**Re: Pascetti Steel Building  
2114 Claremont Ave. NE  
Traffic Circulation Layout  
Architect's Stamp 07-28-20 (H16-D021)**

Based upon the information provided in your submittal received 07-30-2020, the above referenced plan cannot be approved for Building Permit until the following comments are addressed:

TCL
SHEET NO
A1.2

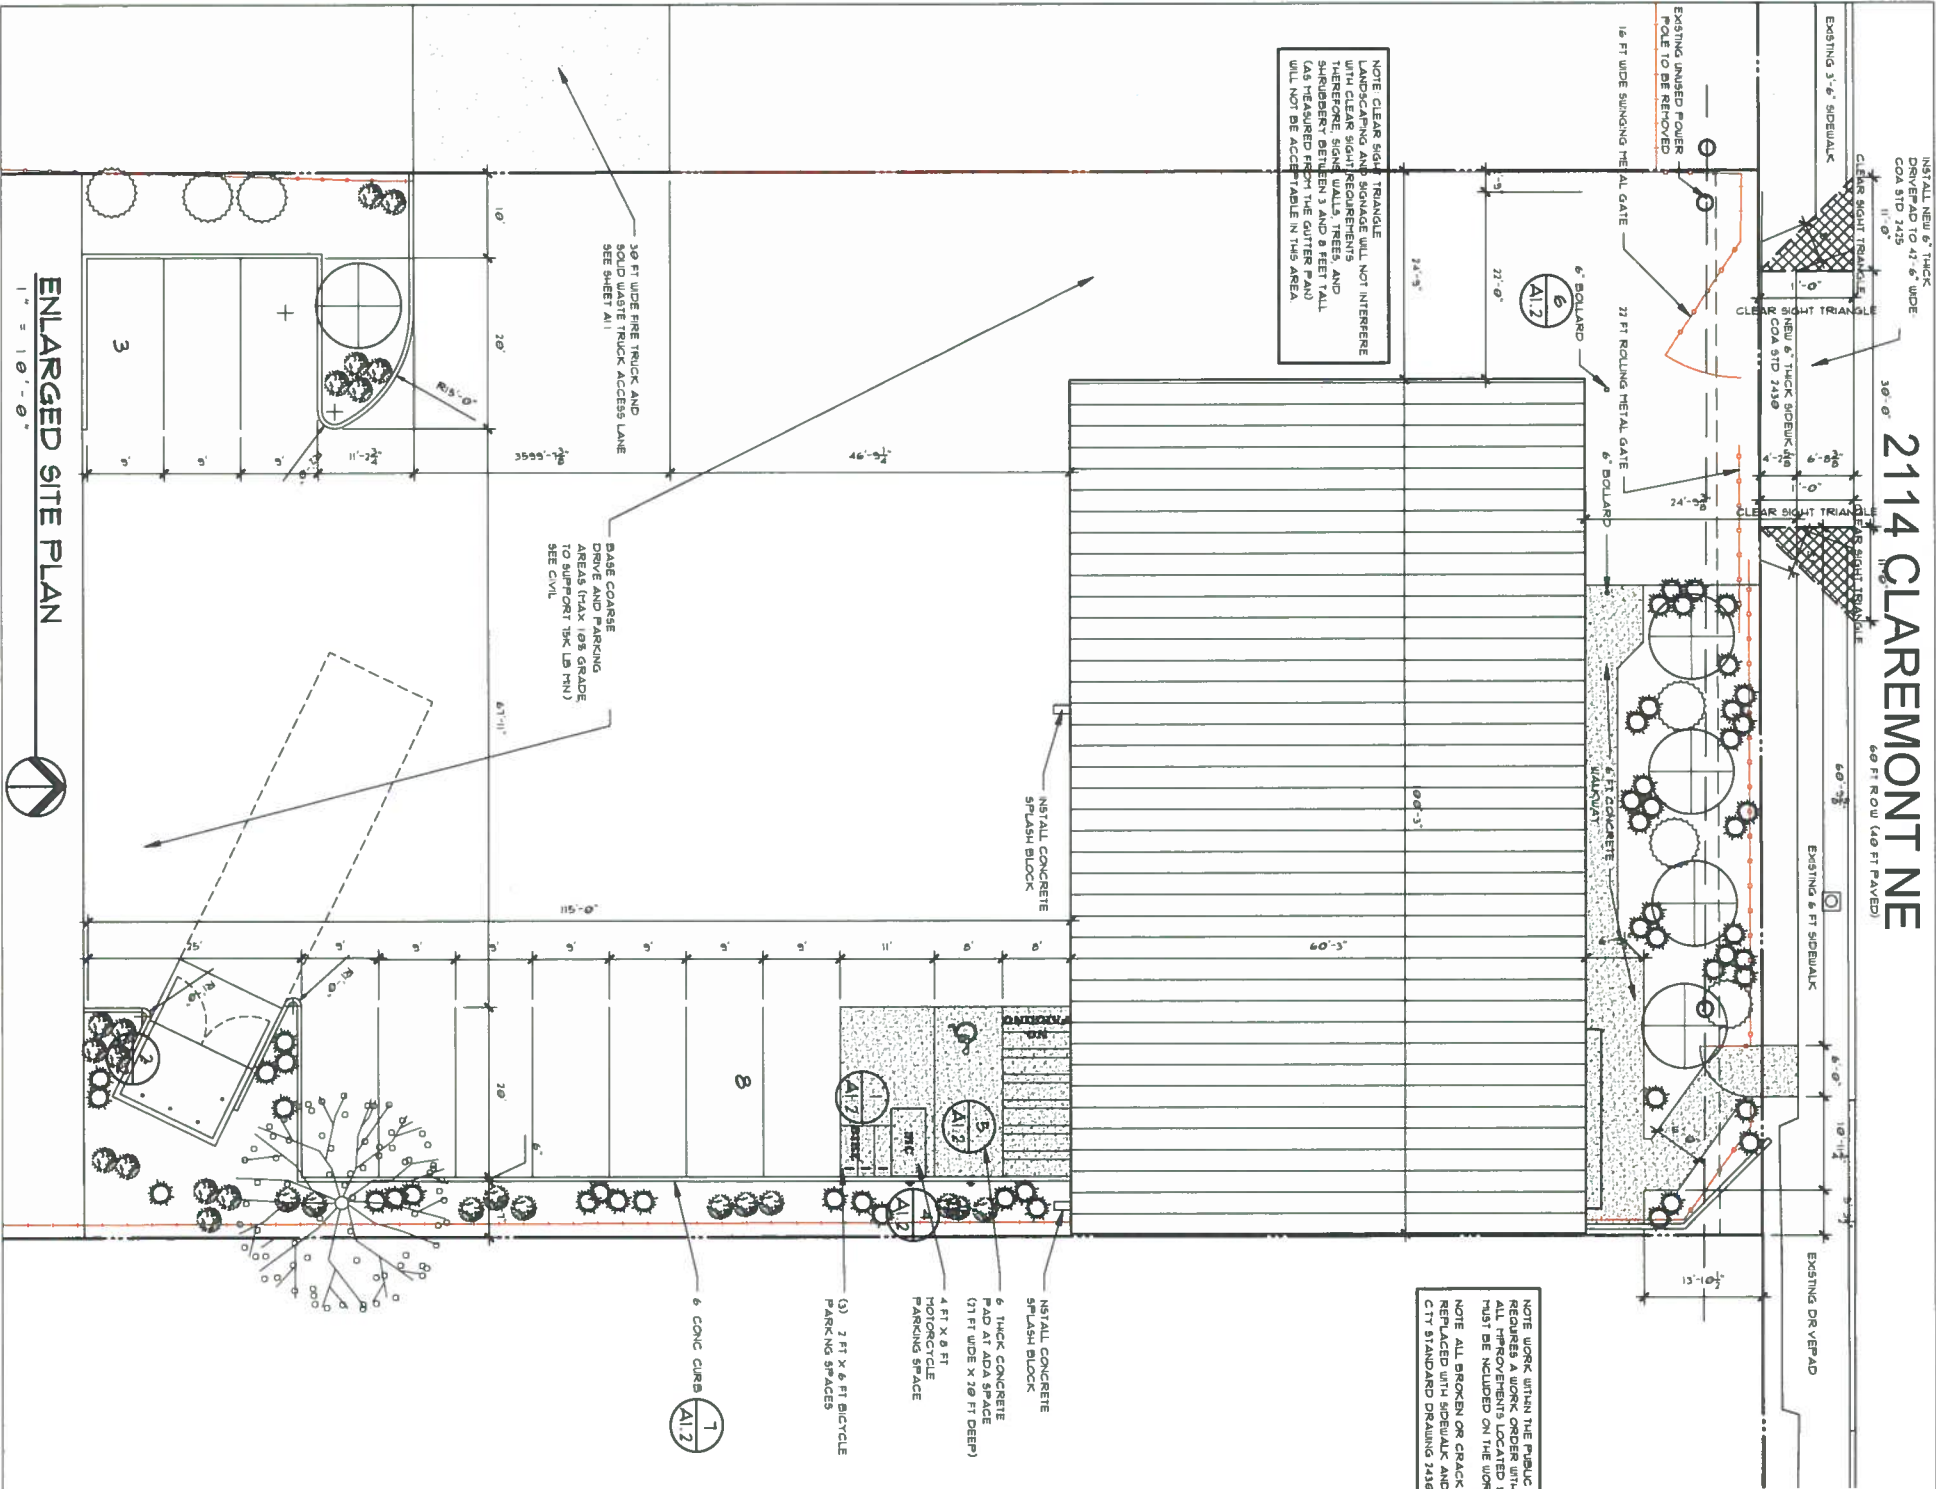
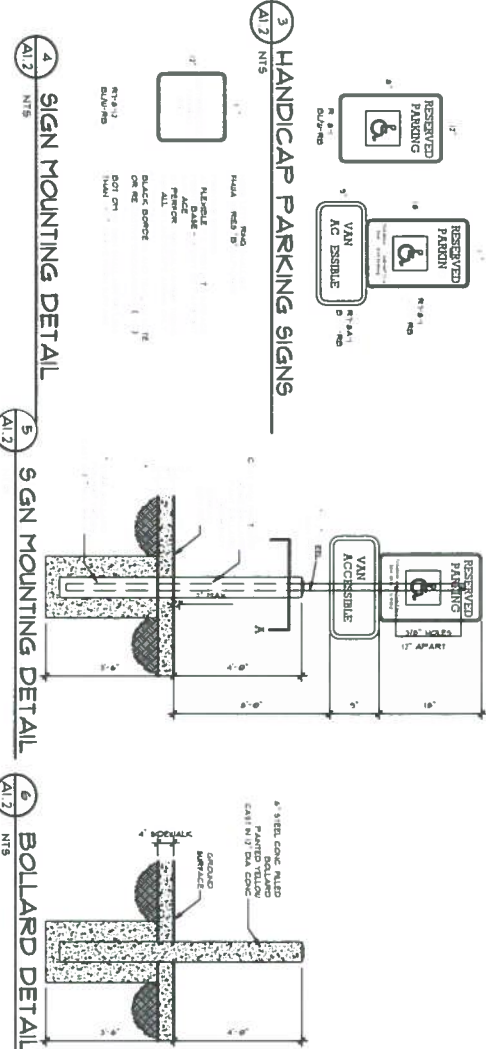
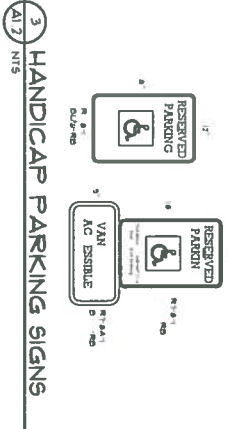
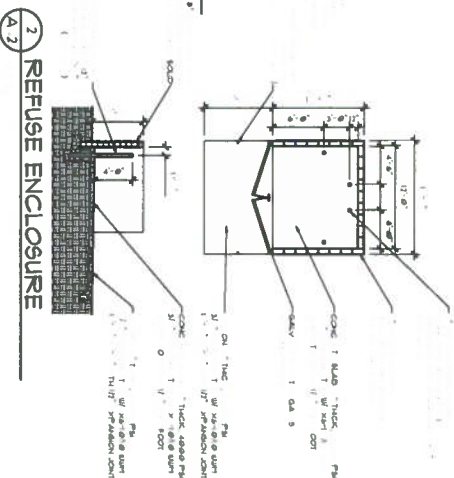
4. Provide existing sidewalk width on Clarmont Ave frontage.
5. Parking bumpers will be required for the proposed stalls.
6. Drive aisle width for two way traffic needs to 22 ft minimum.

7. Pavement will be required between the proposed 43'-9" driveapad and proposed 4' sidewalk (unless you are providing concrete between them and if you are then please label as such for the proposed 6" concrete).

**\*\*You are proposing 43'-9" which is too wide.**

9. The proposed 43'-9" drivepad opening/access is partially block by the New Steel building, please address this concern.
10. The proposed 43'-9" drivepad sidewalk 4 ft width encroached onto the western land owner and will need this landowners approval for the encroachment.
11. The minimum parking stall dimensions are:

17. The proposed bollards: Details will need to be provided and painted yellow.
18. Show all drive aisle widths and radii. Some dimensions are not shown.

20. List radii for all curves shown; for passenger vehicles. Radius for delivery trucks, fire trucks, etc. is 25 ft. or larger.
21. Per DPM, a 6 ft. wide ADA accessible pedestrian pathway is required from the ADA parking stall access aisles to the building entrances. Please clearly show this pathway and provide details.

23. The ADA Van accessible aisle will used for van usage and not public drop off. Please correct statement.
24. Curbing should be installed to **delineate landscape, parking, and pedestrian ways** and identify points of access. Please call out detail and location of barrier curb.

25. Provide a copy of refuse approval.
26. What is the width between the gate opening the drive aisle? Well the gate opening cause any vehicle blockage? Please address this concern of possible obstruction of traffic flow for ingress/'eggress out of the drive aisle and entrance approach.

SHEET NO:
A1.1

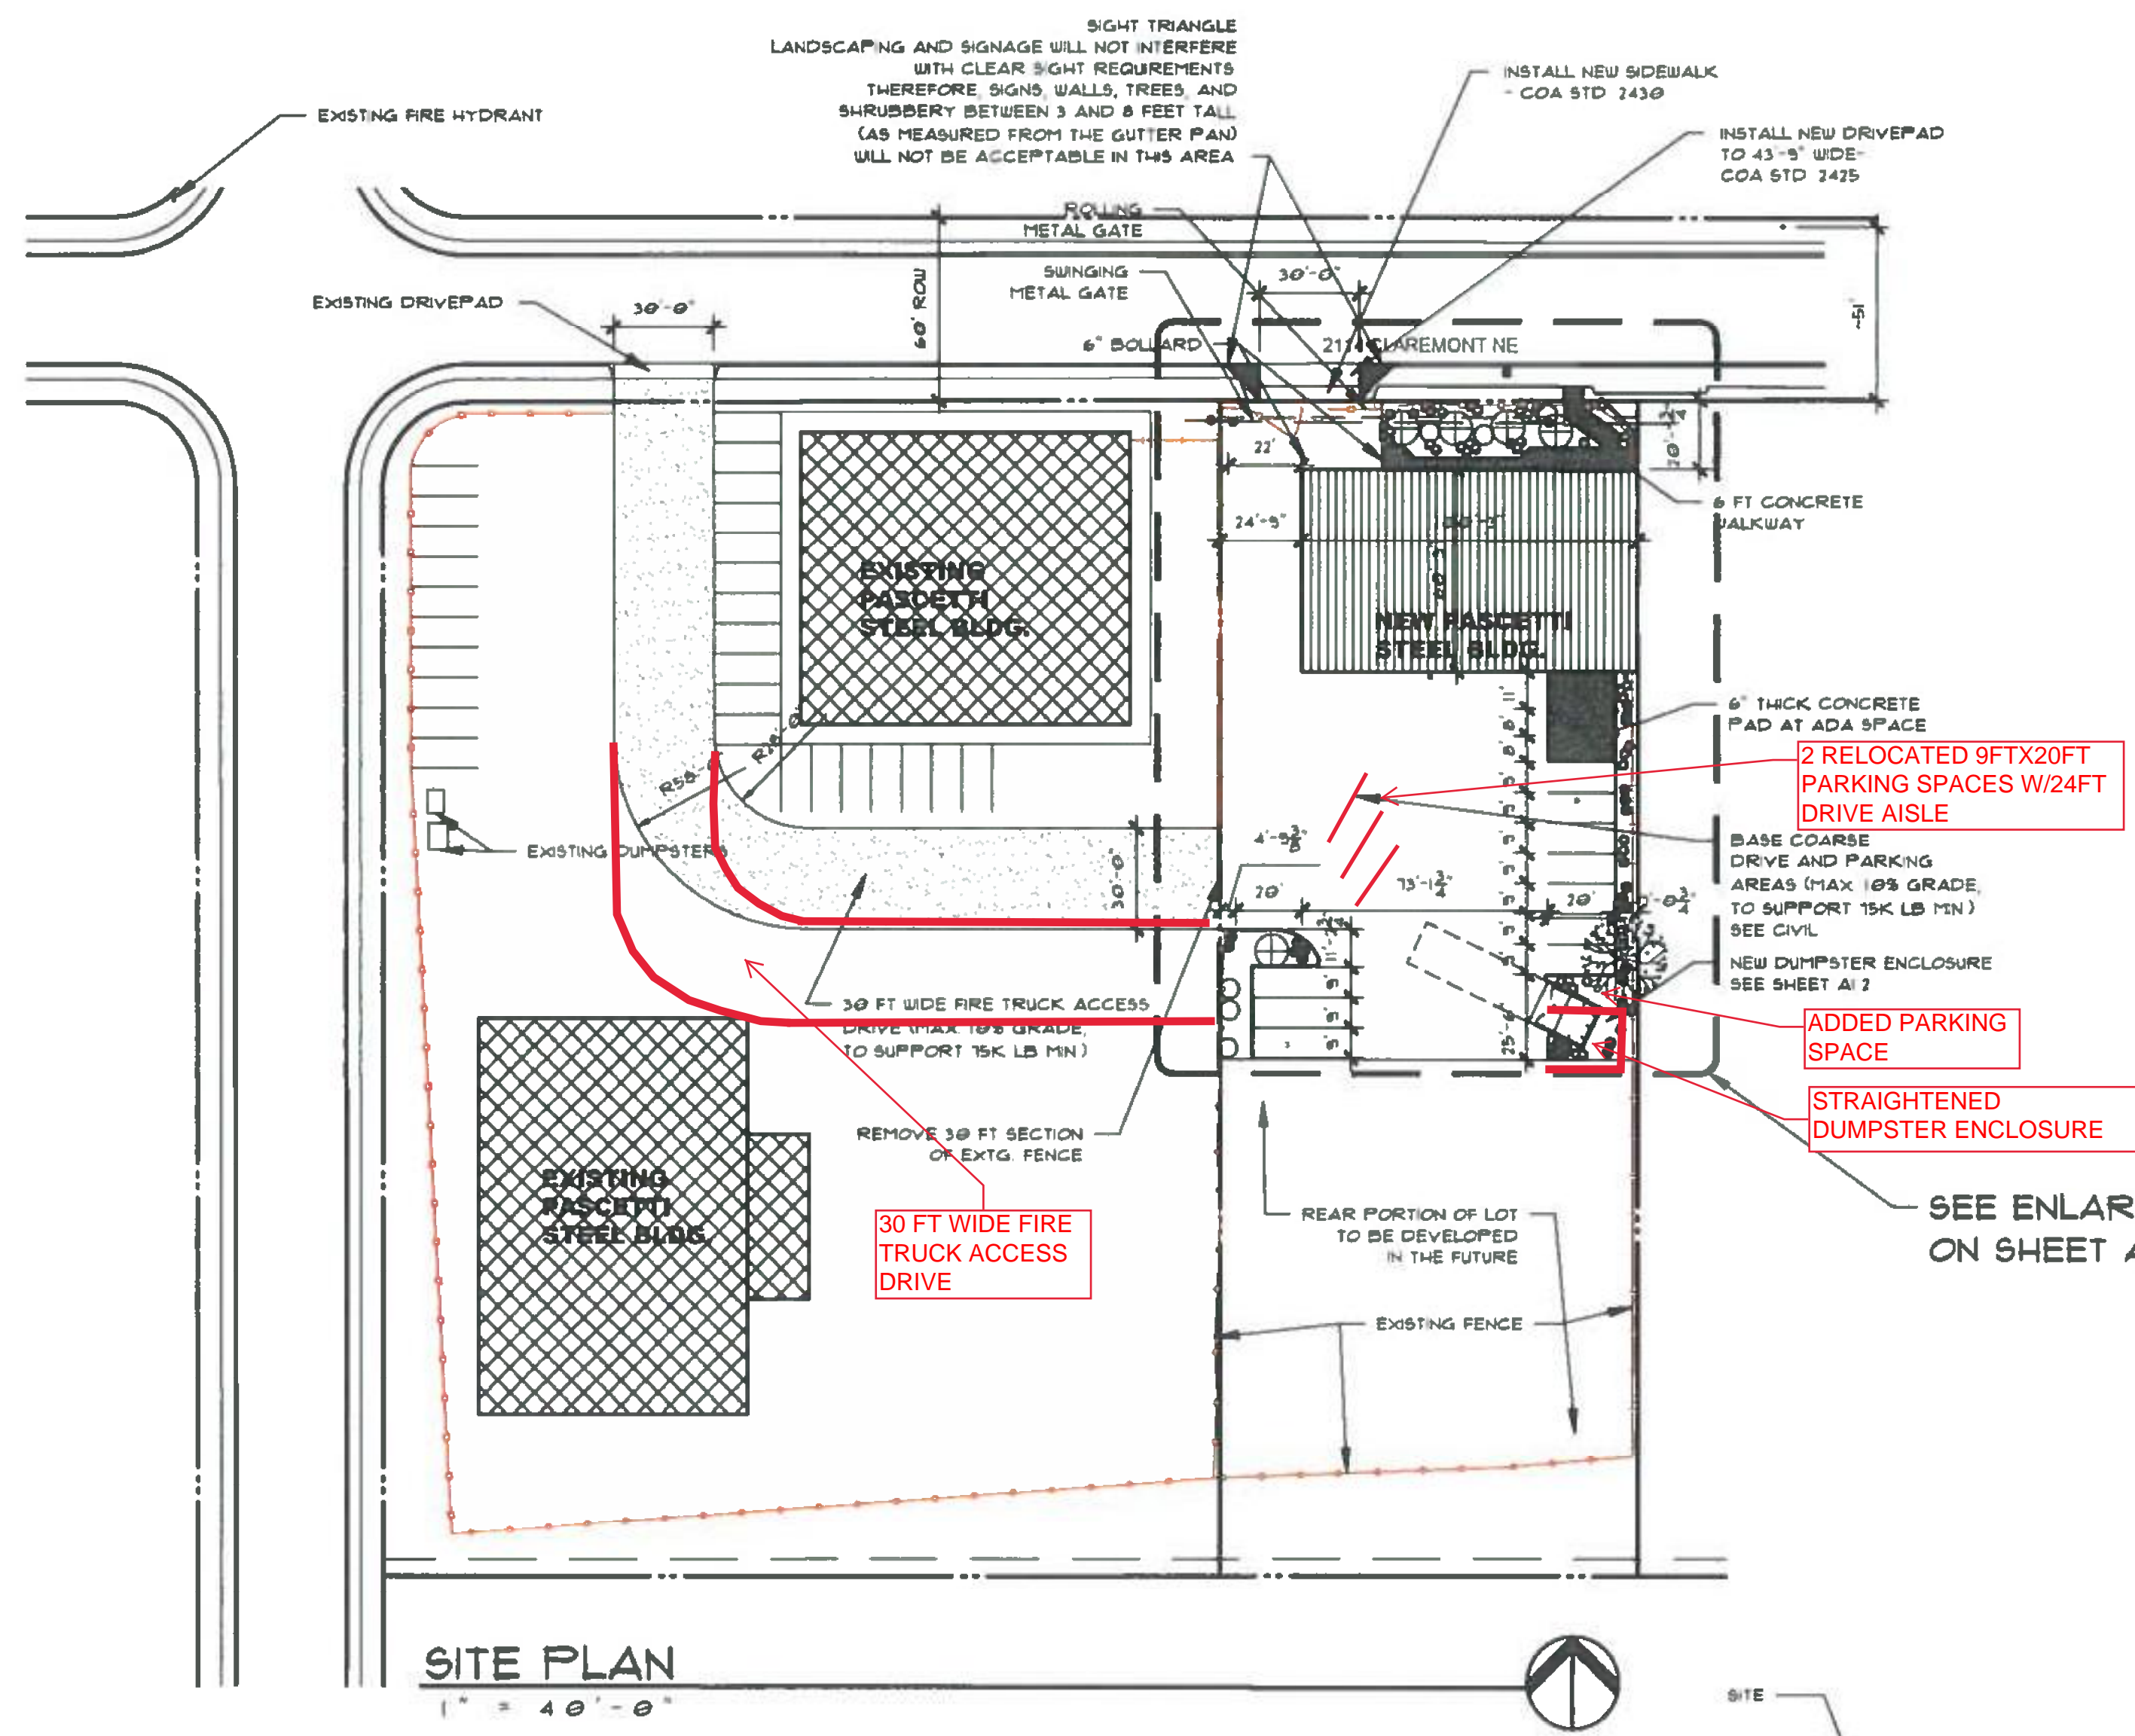
1. Coordination with Zoning is suggested for the listed the number of parking spaces required by the zoning code as well as the proposed number of parking spaces including bicycle and motorcycle parking. These parking stalls are not reflected on your calculations and they need to be addressed.
